# BENT GRASS EAST COMMERCIAL FILING 3

## EL PASO COUNTY, COLORADO PRELIMINARY PLAN

#### COVER SHEET

LANDSCAPE  
NOTES AND  
DETAILS

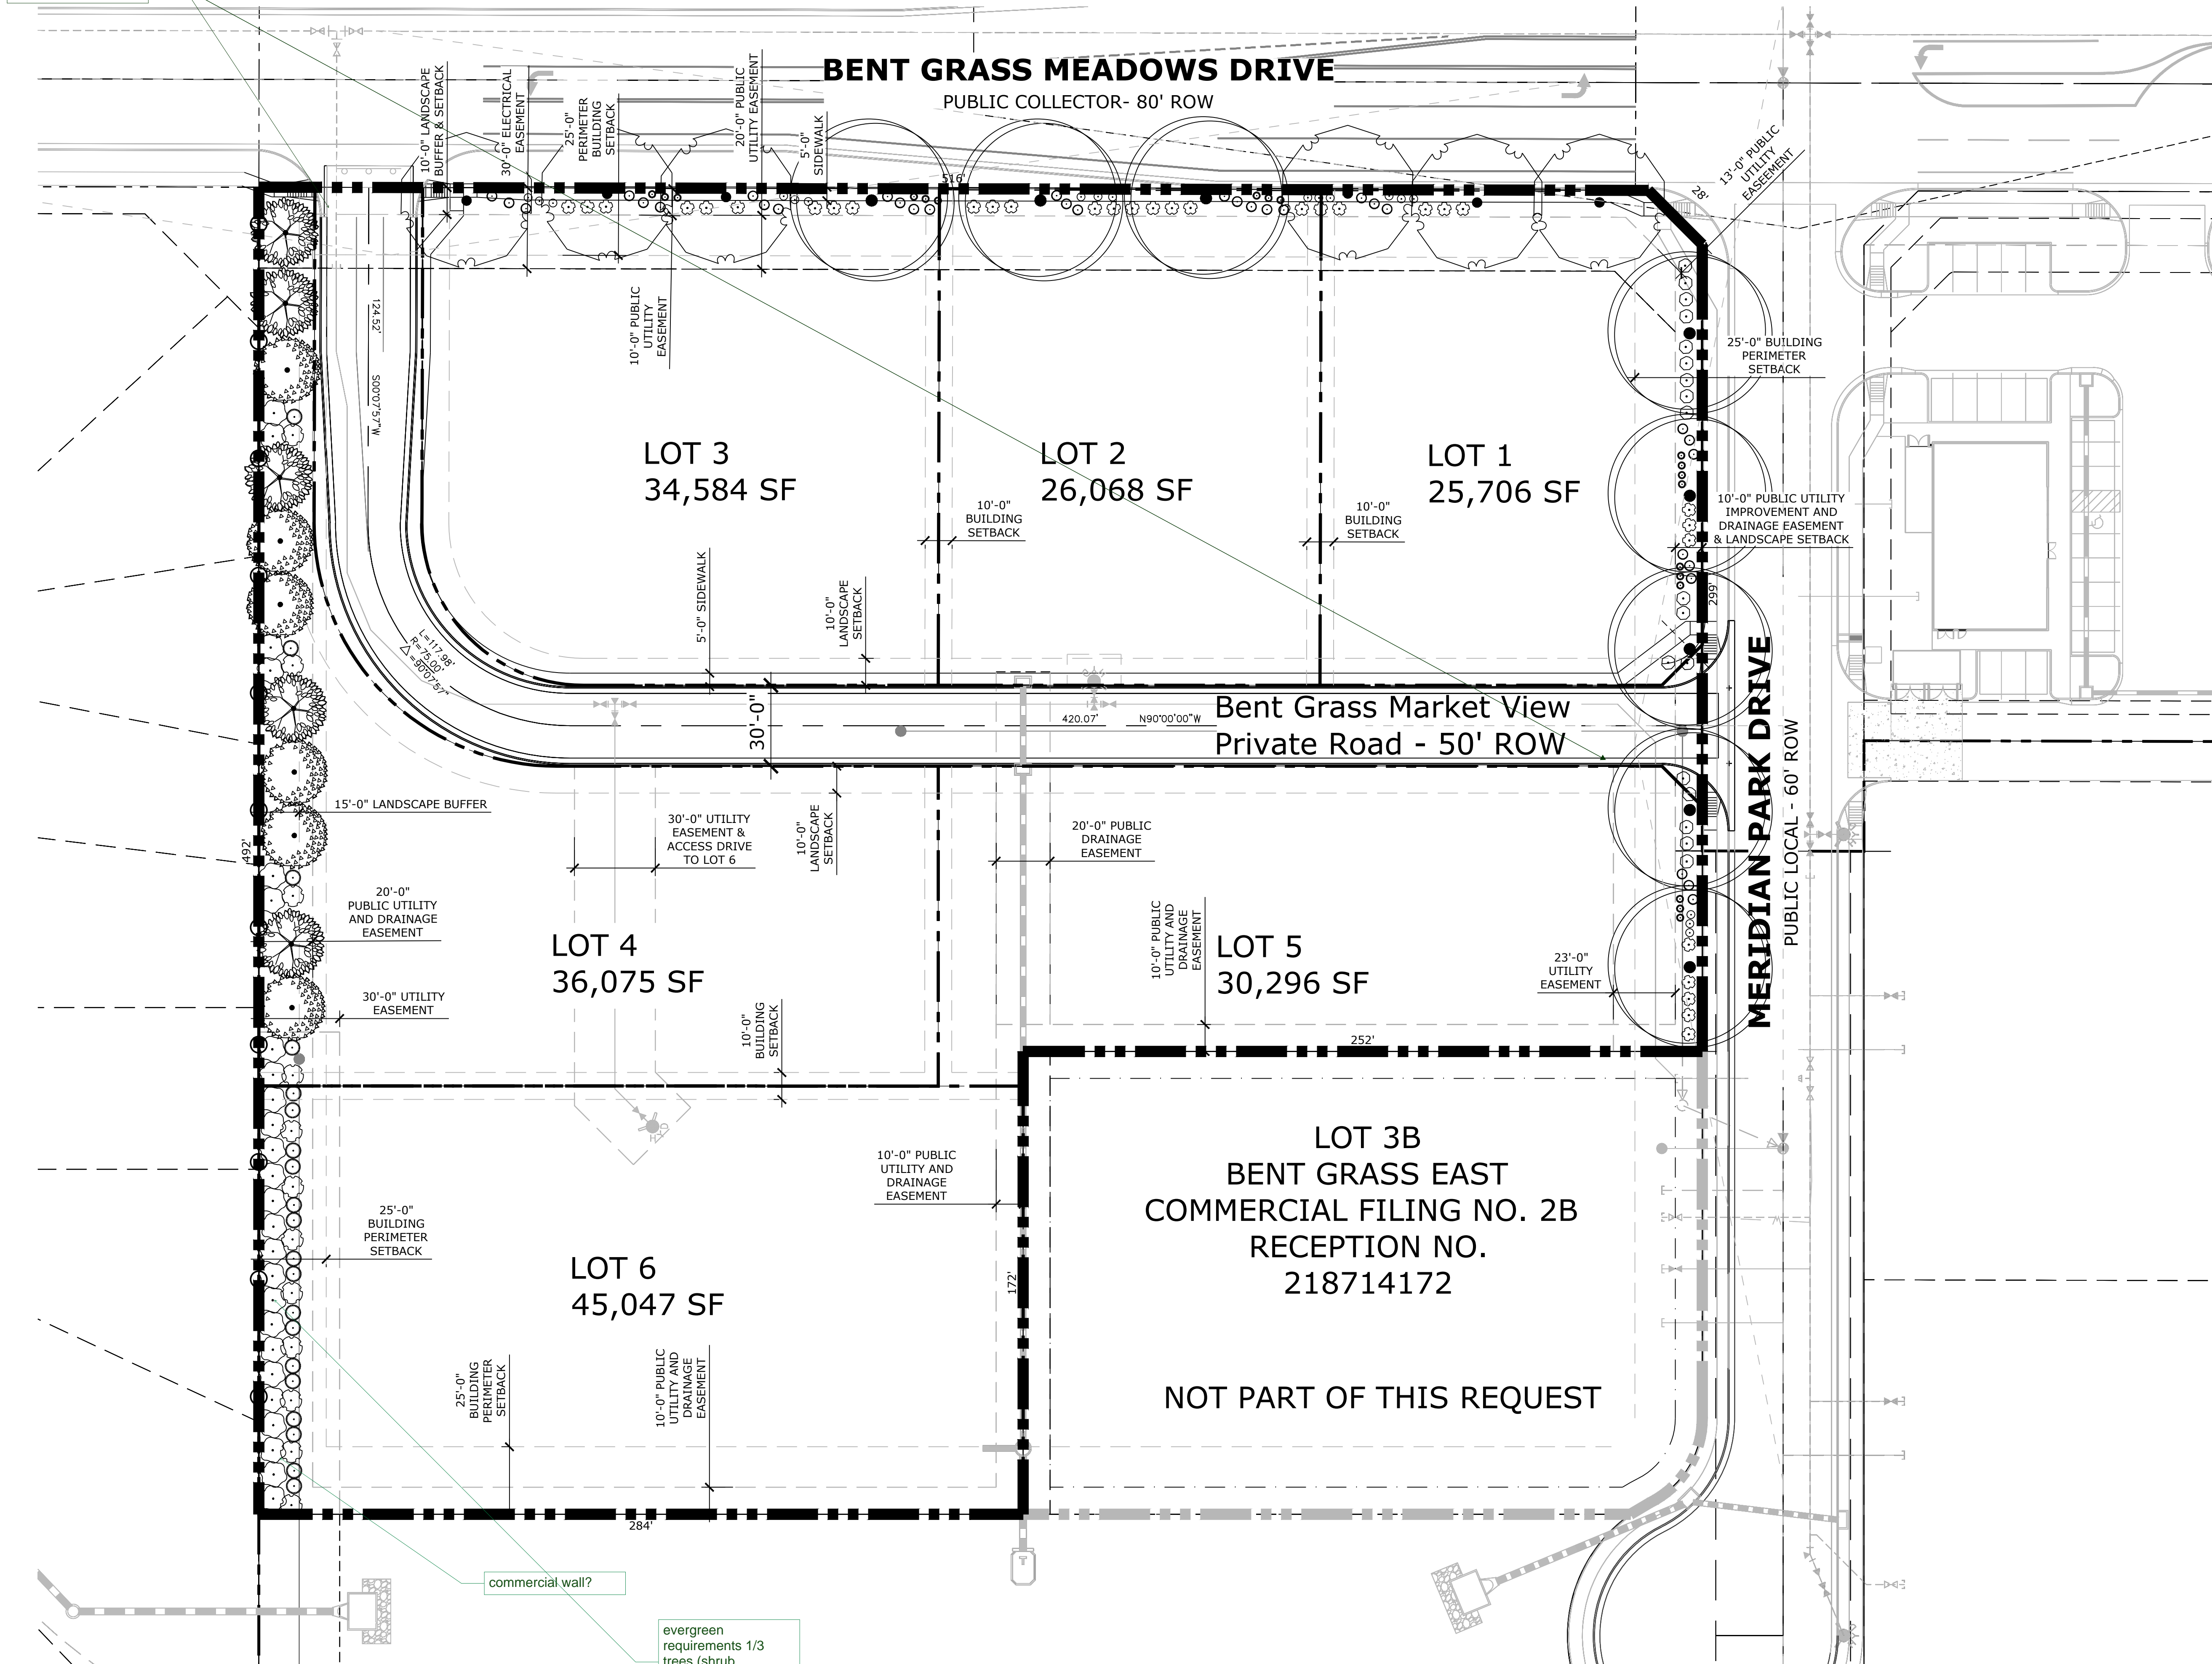
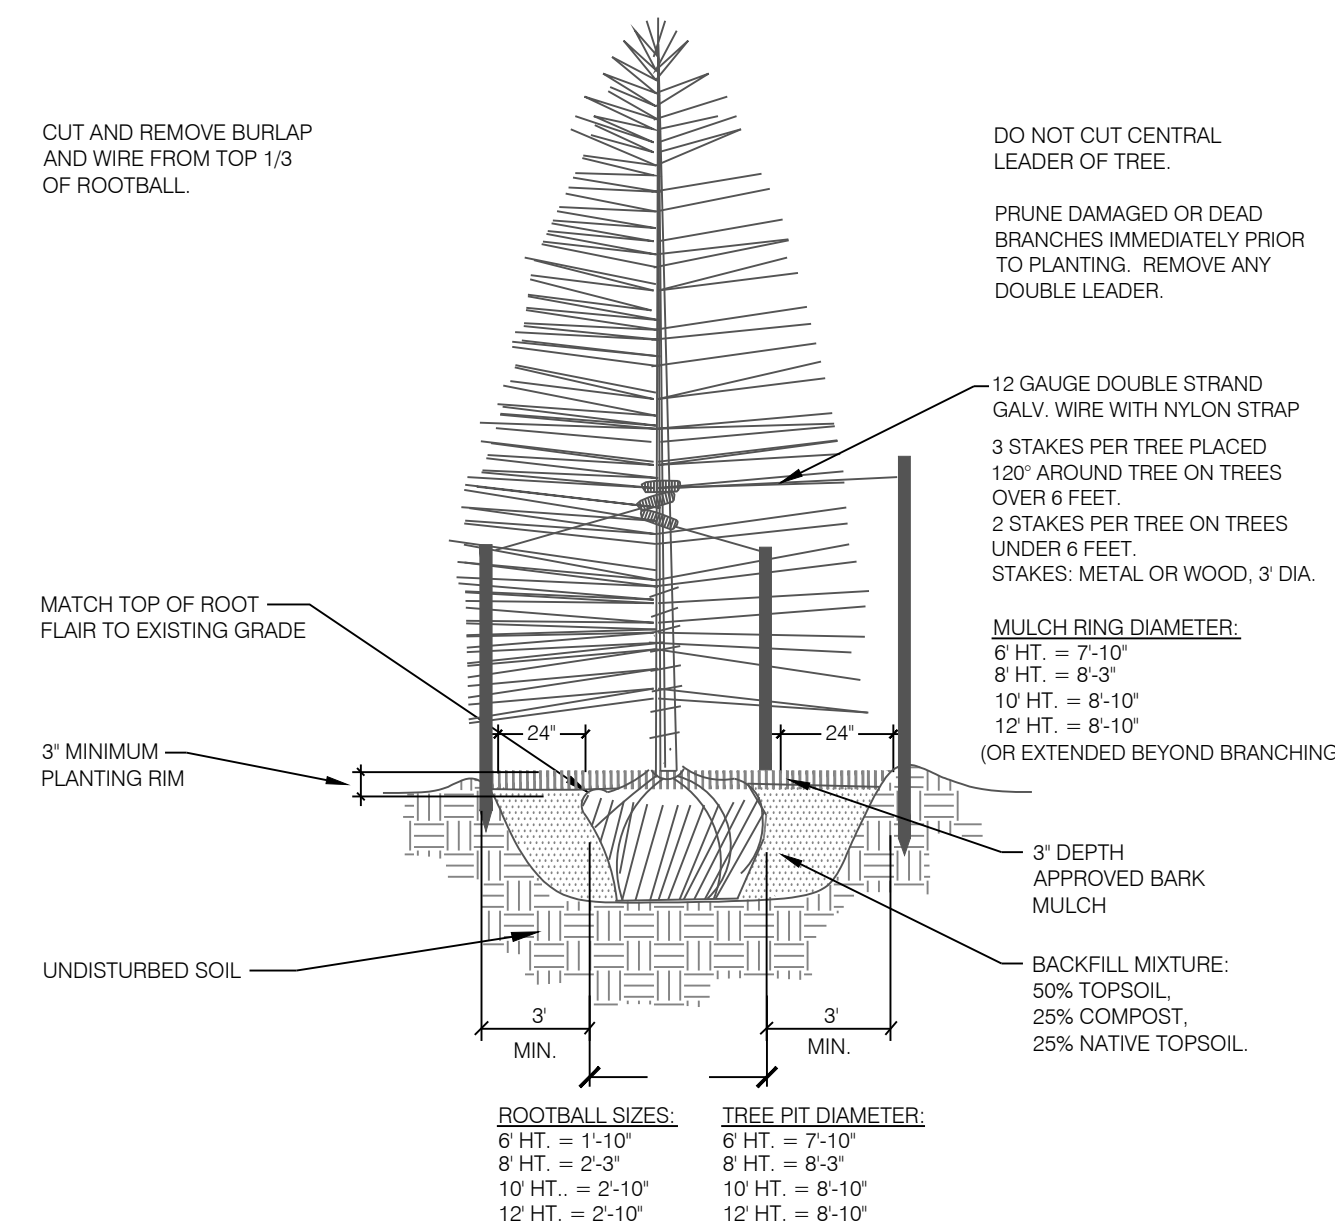
Meridan Park and private road require 10-landscape setbacks.. Do you intend to include the street landscapes and buffers as a requirement for the developer? Or is this plan for all lots to follow? what is the intent with this as it is CR zoning....

site specific lot landscape is required with Site dev plans...ADD note to this plan

please update to meet Code

Addressed

Addressed

Updated

Buffer has been added
